## Inspector's Report ABP-317659-23

Whether the (a) demolition of a two-storey extension measuring 92 sq. m. to the rear of dwelling, (b) construction of new two-storey extension measuring 129 sq. m. to the rear of dwelling, (c) demolition of a single storey sunroom measuring 5 sq. m. on the western side elevation, (d) construction of a single storey extension measuring 2 sq. m. on the western side elevation, (e) construction of lean-to roof on the western elevation measuring approx. 6900mm long and 160mm wide and (f) construction of a wooden fence measuring 2m in height along the western boundary in the front garden of the house is or is not development or is or is not exempted development.

10 Burrow Road, Sutton, Dublin 13

GROUND FLOOR PLAN EXISTING
(AS PER CONSTRUCTION & RENOVATION)
SCALE 1:100

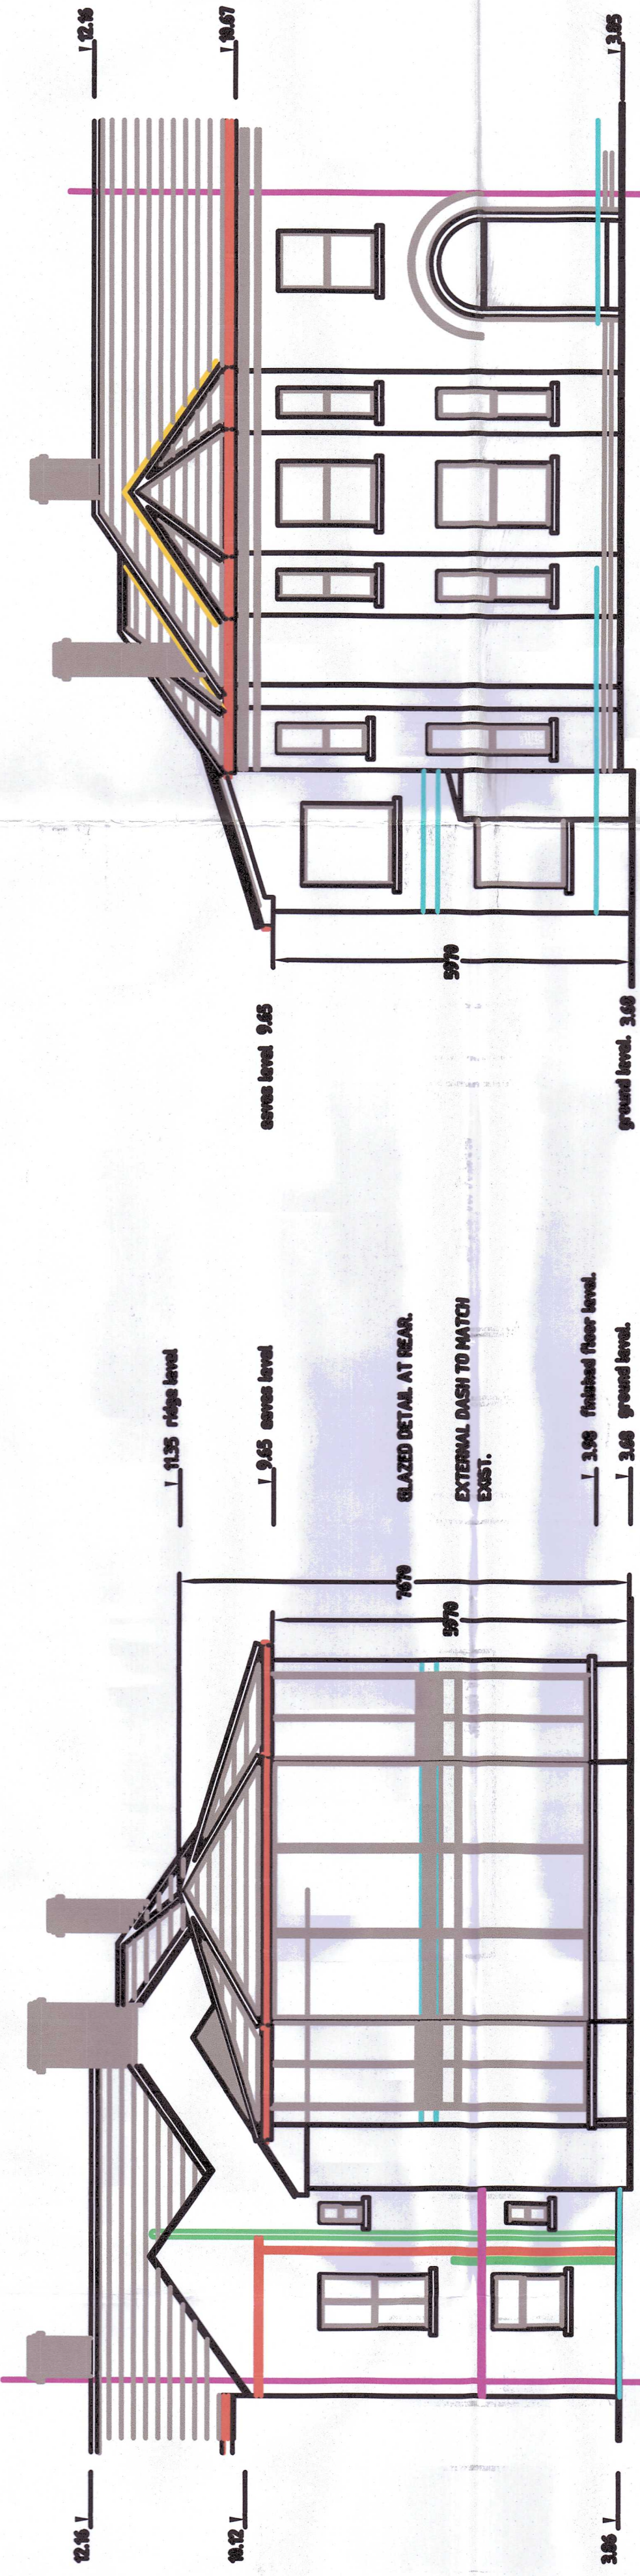
- In or around 2000, a 5sqm single storey sunroom was added to the western elevation without the benefit of planning permission.
- Mr. Farrelly disputes the dimensions as shown on the Fingal County Council drawings. He contends that the total area of the new extension is 123sqm and not 129sqm as indicated by FCC. The extension comprises the reconstruction of the 92sqm (demolished area) and an additional 31sqm (25sqm at ground floor level and 6 sqm at first floor level).

- The sunroom was demolished and replaced by a bay window extending to 2sqm.
- Drawings 202-005/A2 and 2020-005/A1 have been submitted as part of the referral response statement. It is stated that these drawings were submitted to FCC in July 2020.

CURRENT FRONT ELEVATION (SOUTH) WITH NEW EXTENSION
Scale 1:100 @ A1

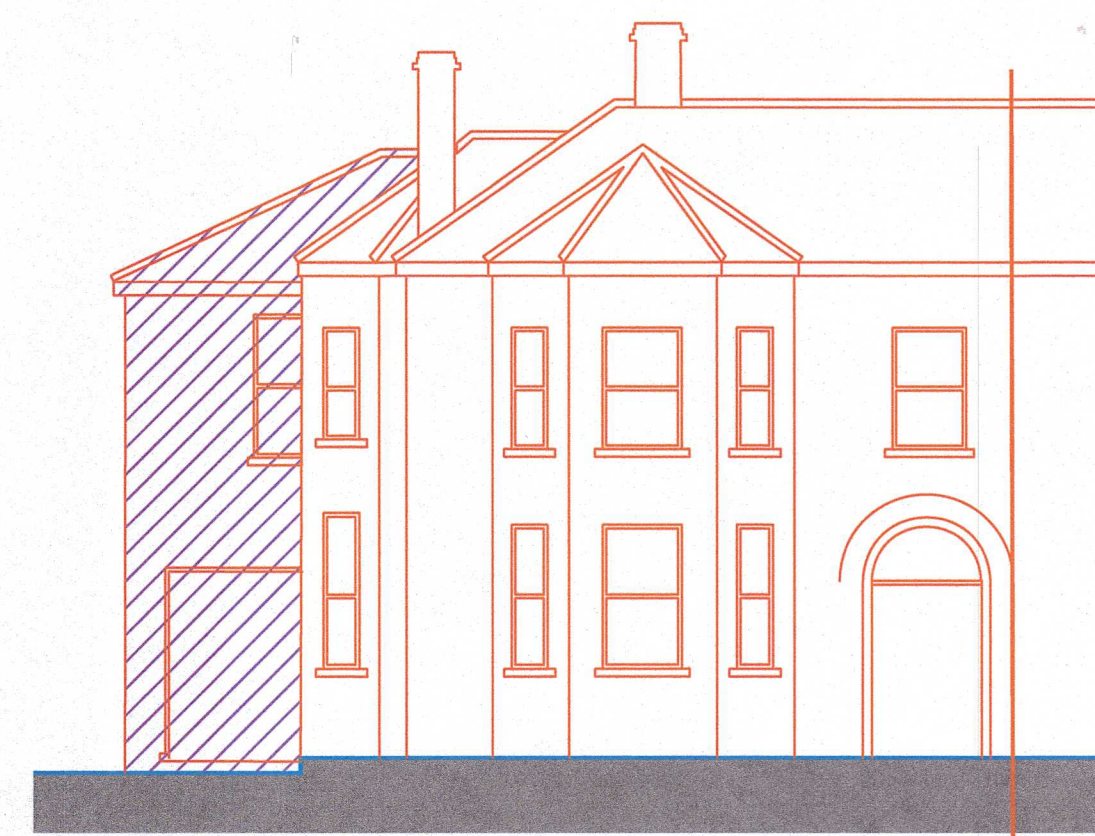
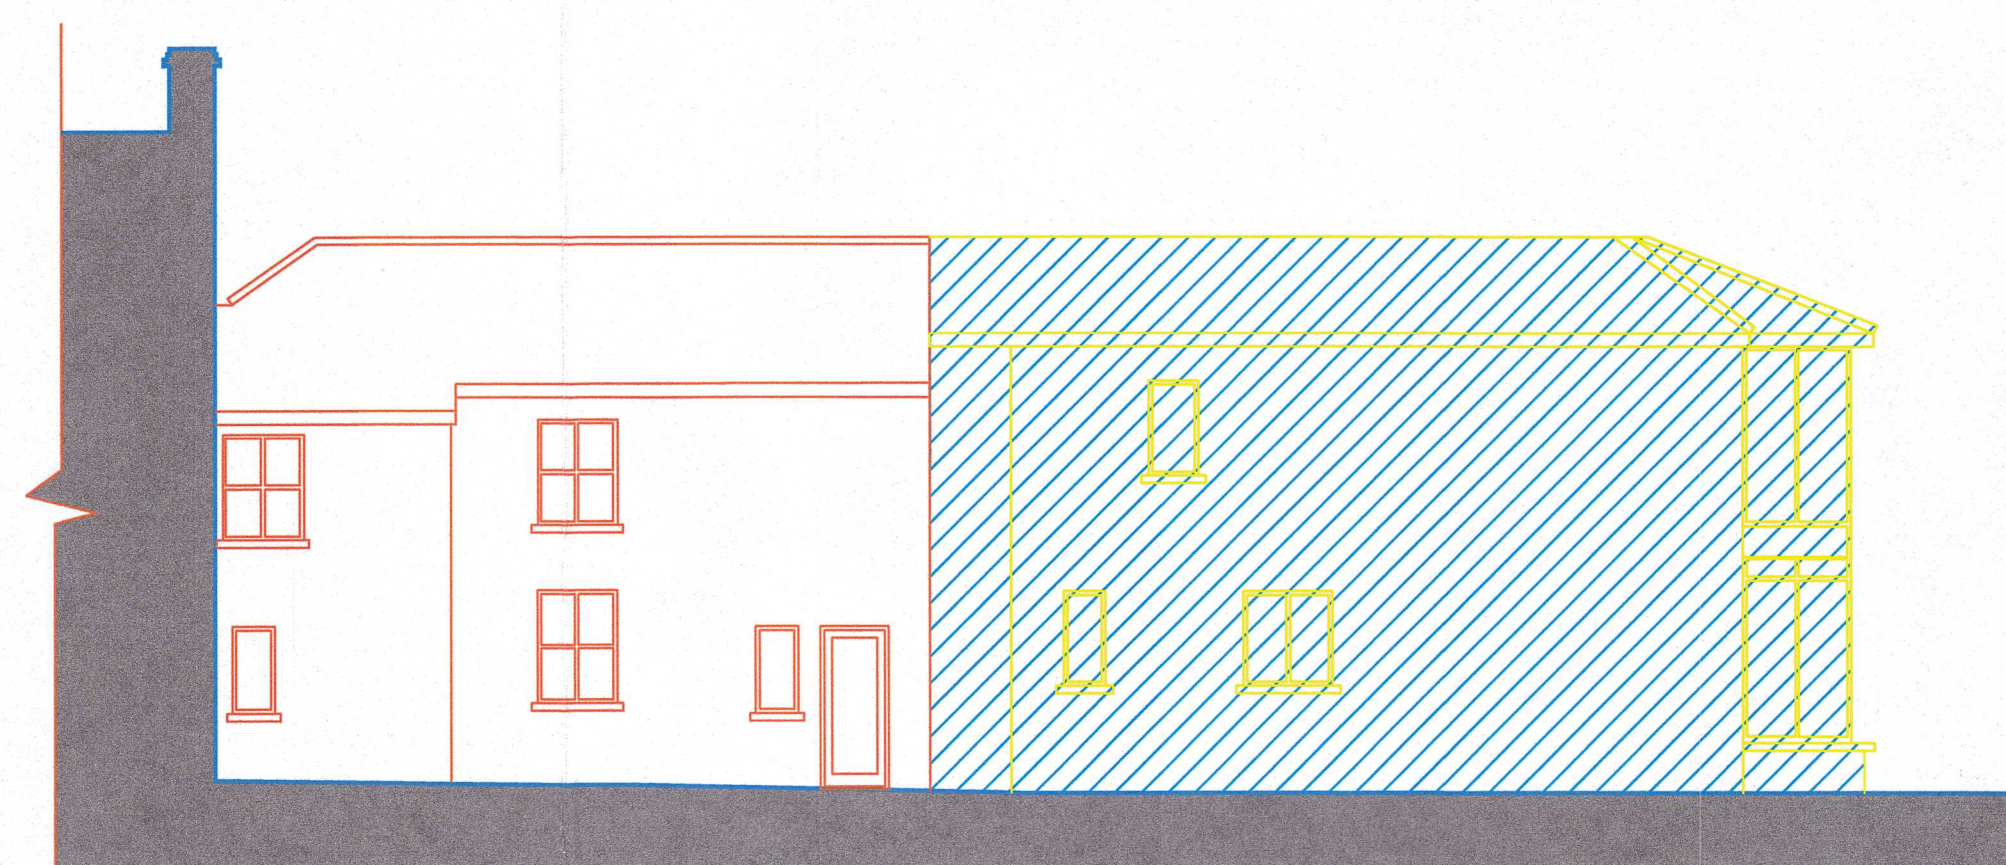
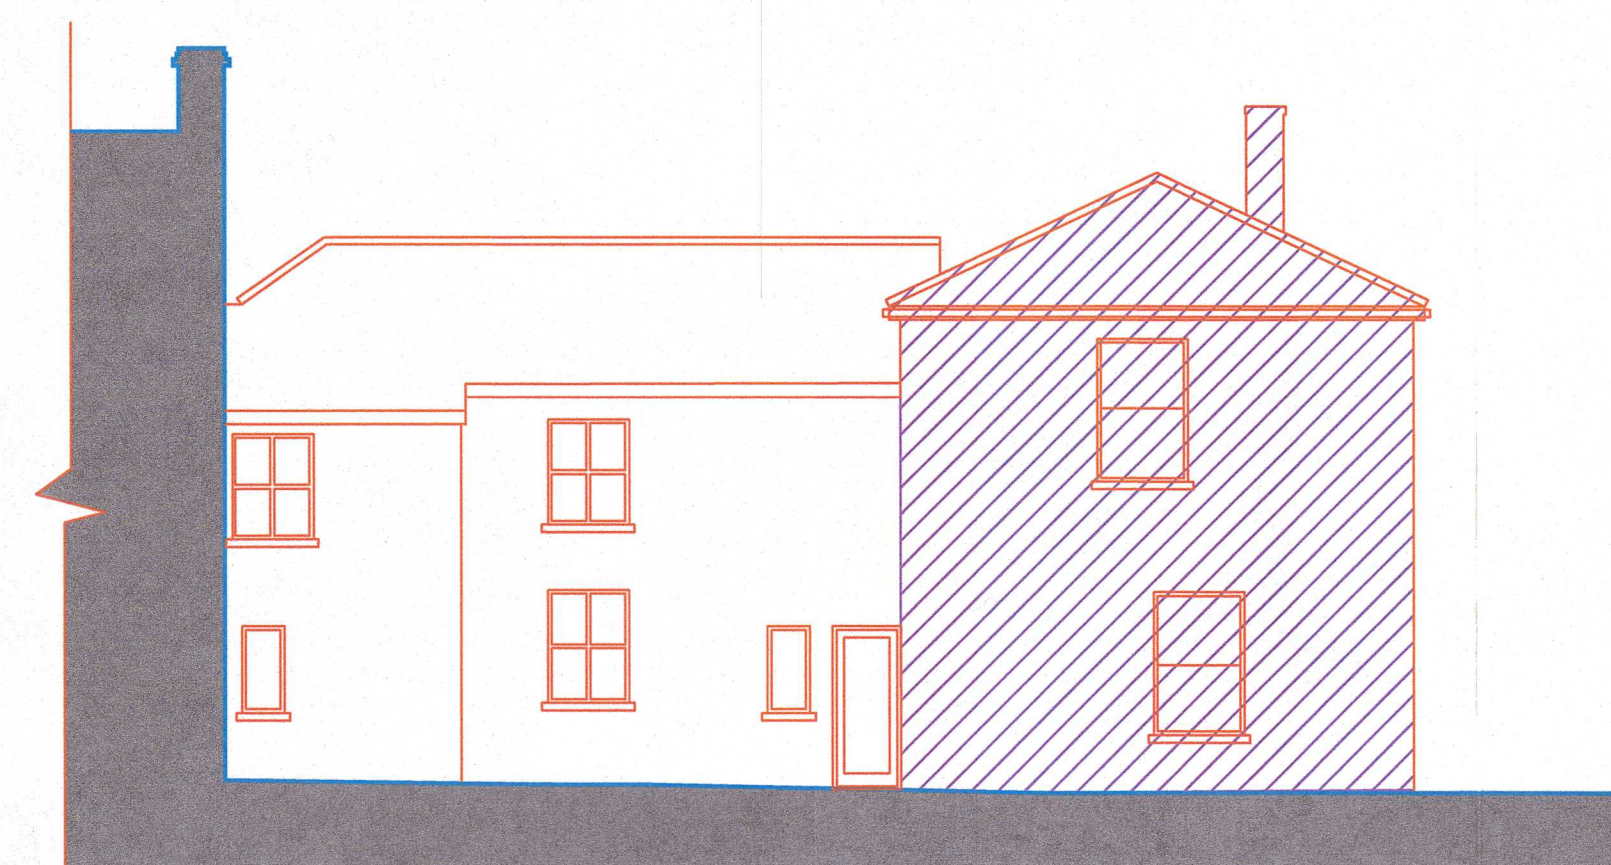
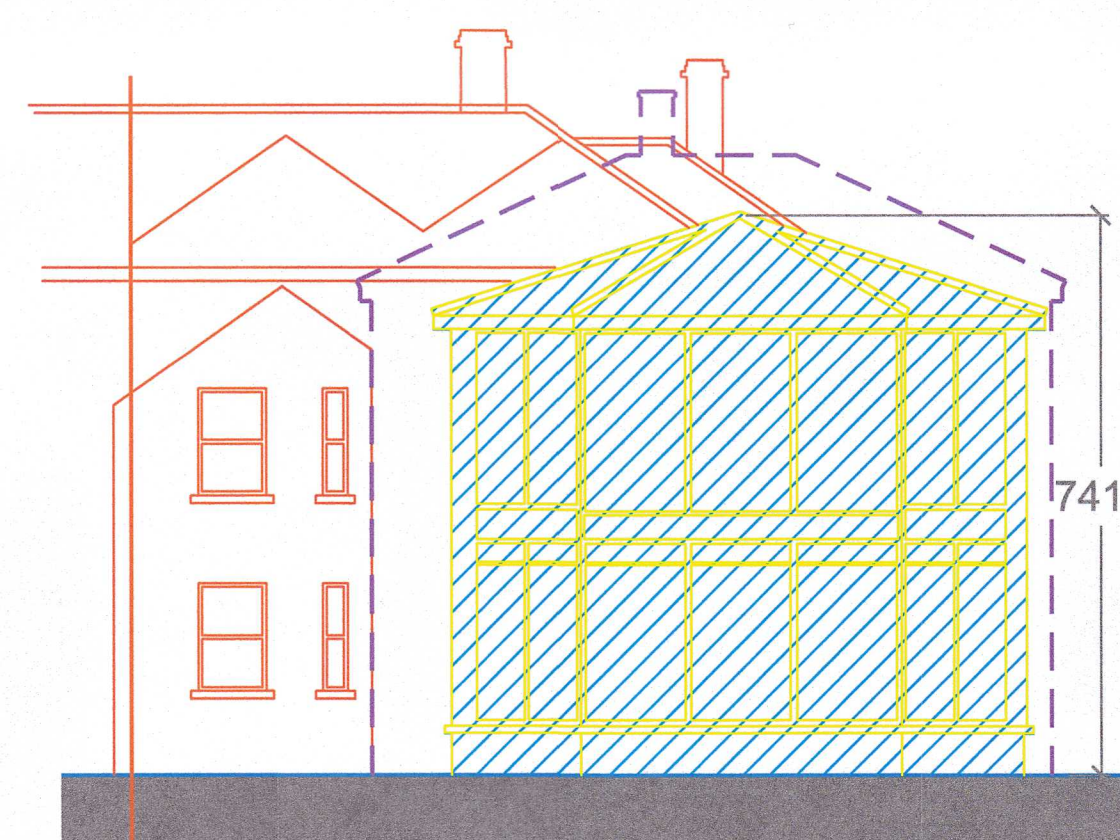
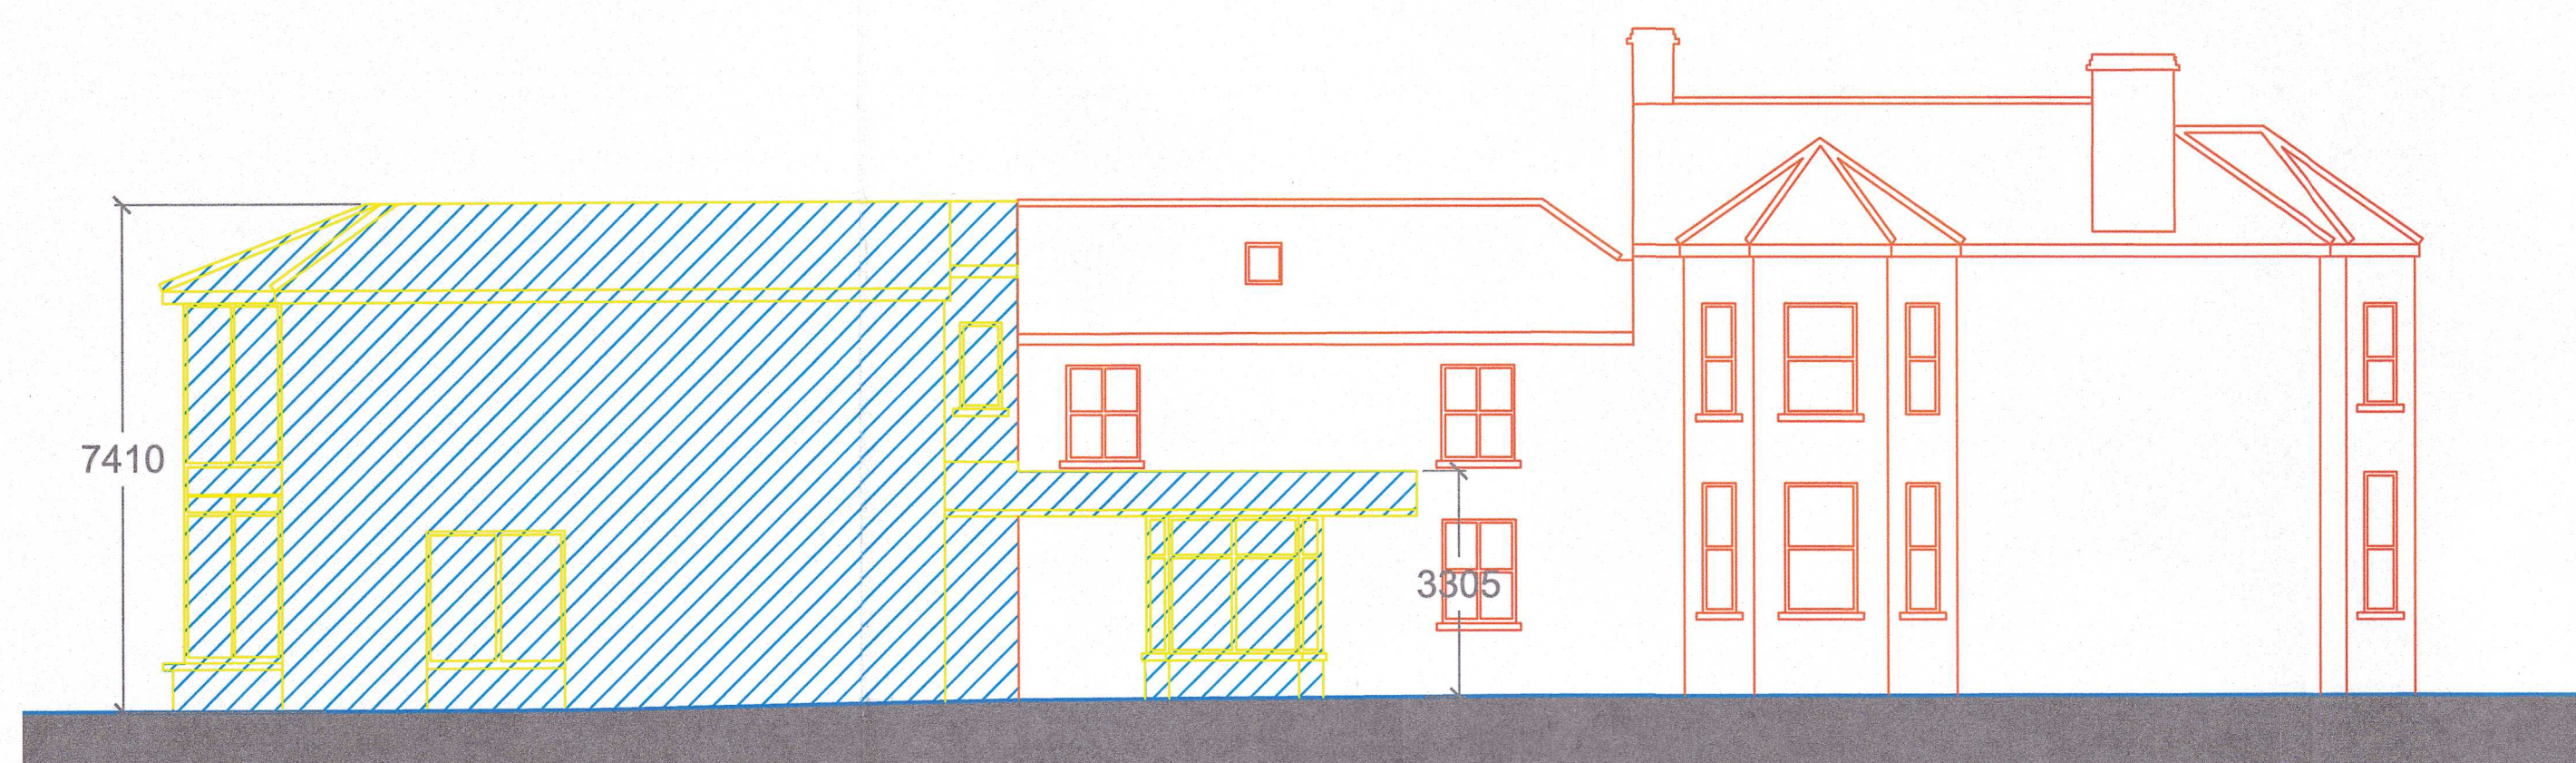
- **Cond. 4** relates to the height of the extension. As the rear wall of the original house includes a gable, it is a requirement under Cond.4(b) that the walls of any such extension not exceed the height of the side walls of the house. As

detailed on the elevation drawings submitted by FCC, the height of the side walls of the original house steps down from c6.3m at the front to c5.1m at the rear (original rear projection, which includes a gable). The walls of the extension, at c5.8m (measured from drawings submitted by FCC), do not exceed the height of the highest part of the side wall of the house. In compliance with Cond.4(c), the height of the highest part of the roof of the extension does not exceed, the height of the highest part of the roof of the dwelling.
